KITTITAS COUNTY

MEMORANDUM

TO: Dusty Pilkington, CDS
FROM: Kelly Bacon, Engineer Technician I *KB*
DATE: July 15, 2016
SUBJECT: Bailey BL-16-00009 – Amended Comments

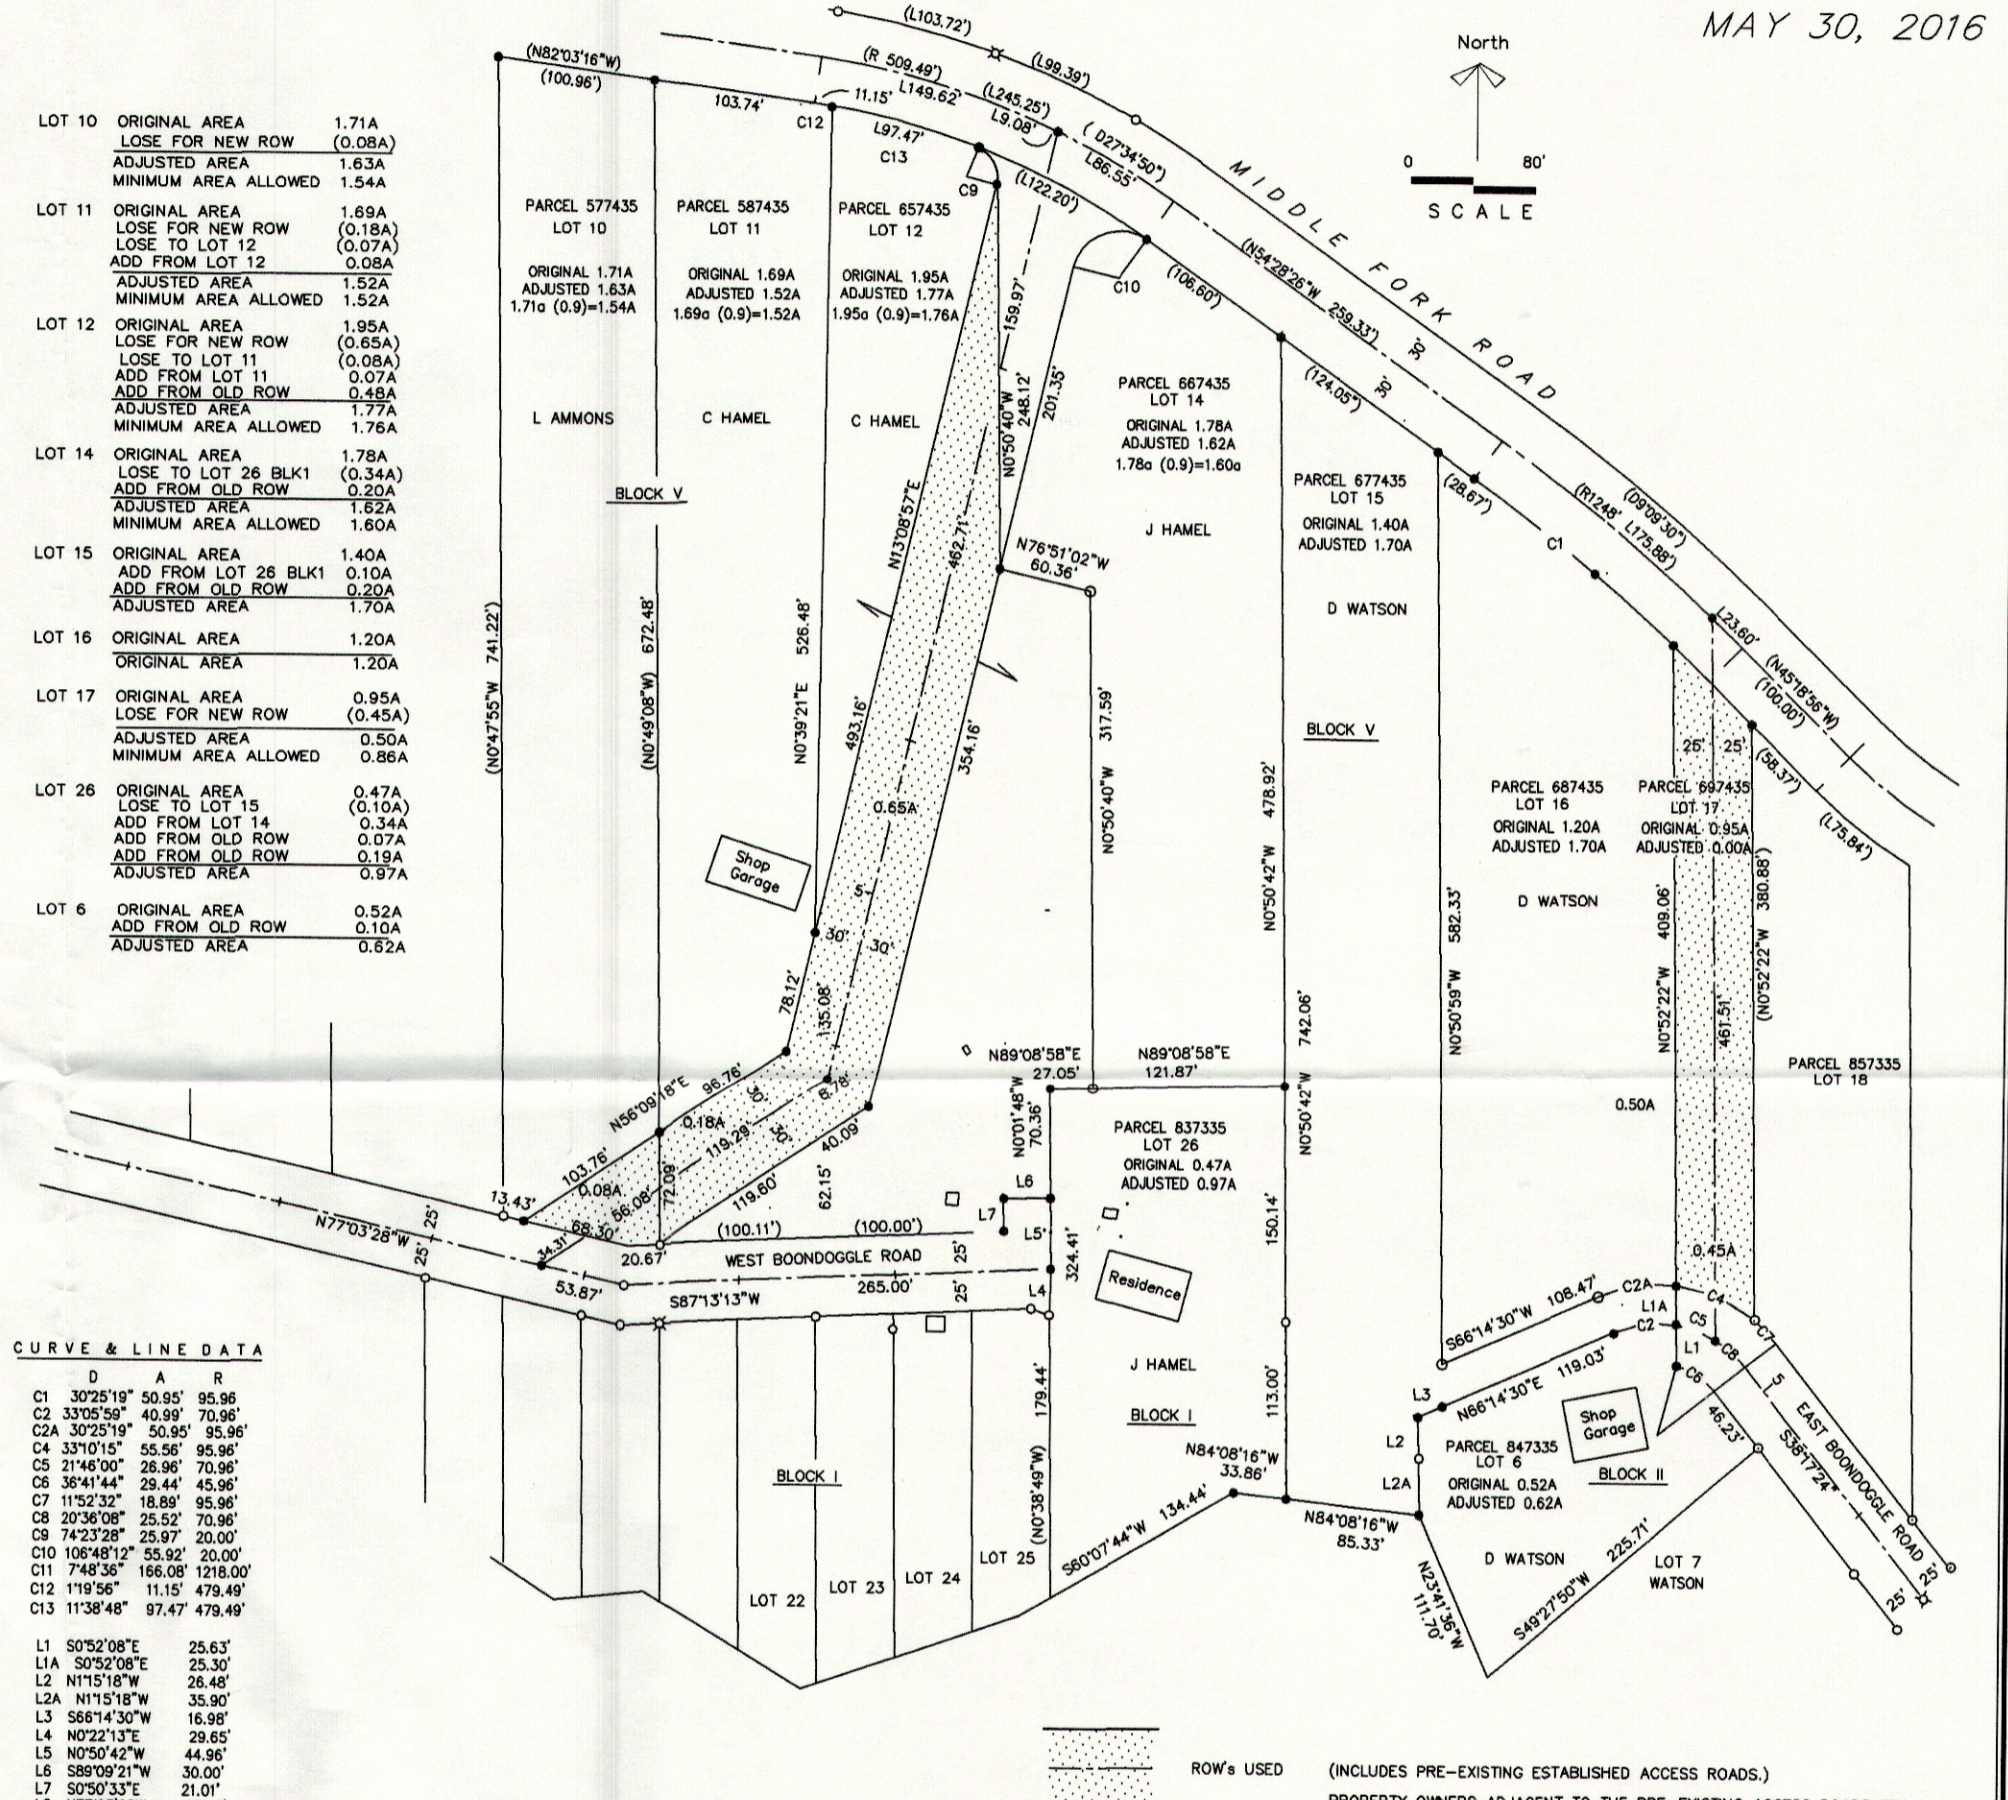
- A. Private Road standards allows for existing access easements to be a minimum of 40 feet wide. The proposed 50' access easement is sufficient for the existing access road.

- B. A hammerhead needs to be shown on the face of the BLA for West Boondoggle Road where it ends at lot 25. Per discussion with applicant, the 2015 International Fire code Appendix D Fire Apparatus Access Roads – acceptable alternative to 120' hammerhead, will be used.
